20 November 2015

**REVISED ADDENDUM TO RESPONSE TO SUBMISSIONS REPORT - AUGUST 2015 PREPARED BY TCG PLANNING**  
**Kembla Grange Resource Recovery Facility Building Material Storage and**  
**Resource Recovery Facility Exceeding 30,000 Tonnes per Annum and**  
**Redesign and Expansion of Approved Facility**  
**Lot 10 DP 878167, 50 Wyllie Road, Kembla Grange, Application No. SSD-5300**

SITE PLAN
NTS

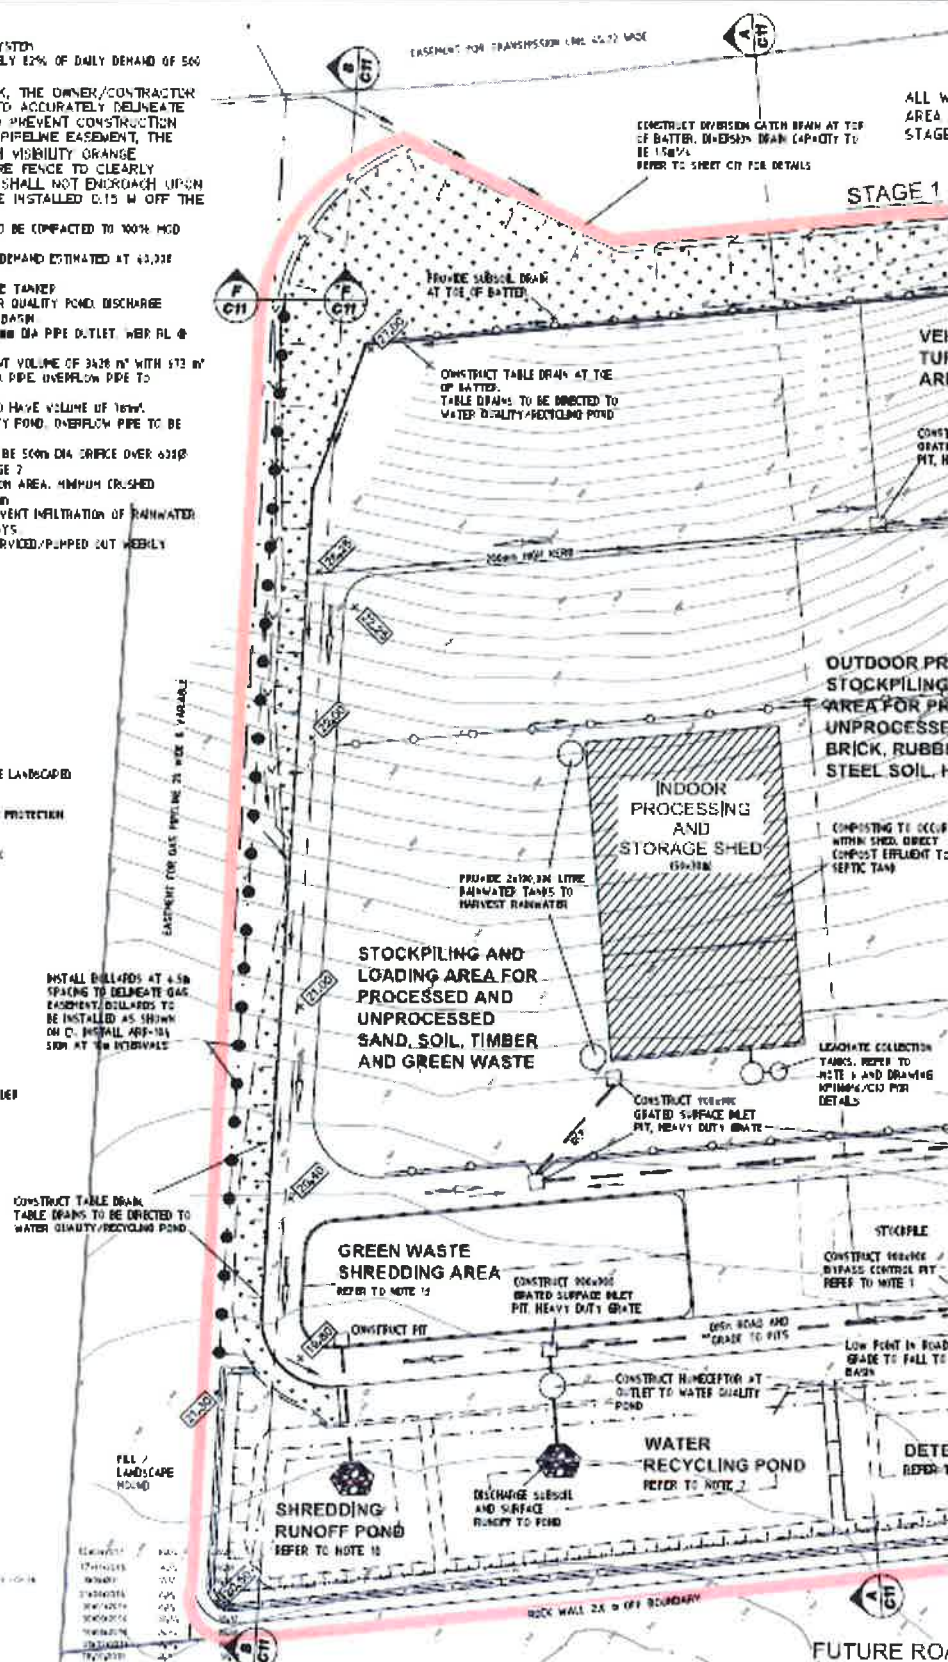
The Department of Planning and Environment has also requested that the proponent submit a plan detailing the staging of the development which is proposed. In this regard the proposed staging is depicted on the accompanying "Stage Plan" prepared by KFW Reference KF 110816 Drawing C39 dated Nov 15 (and updated accordingly on other relevant plans). As referenced in previously submitted documentation prepared by TCG Planning, approval is sought for the undertaking of the development in two stages, with each stage to incorporate the following works:

- **Stage 1:** The undertaking of all works and the erection of all buildings, including the expansion of the capacity of the facility to 230,000 tonnes per annum, with the exception of works to the east of the watercourse.
- **Stage 2:** The undertaking of all works to the east of the watercourse including the construction of the Buildings E, F and G (as referenced on plans prepared by DJ Little Design Ref: 21304 Sheets 1-22) being the workshop, OHS training room and office building; construction of on site detention basin (OSD) B; the truck parking/ access and associated earthworks.
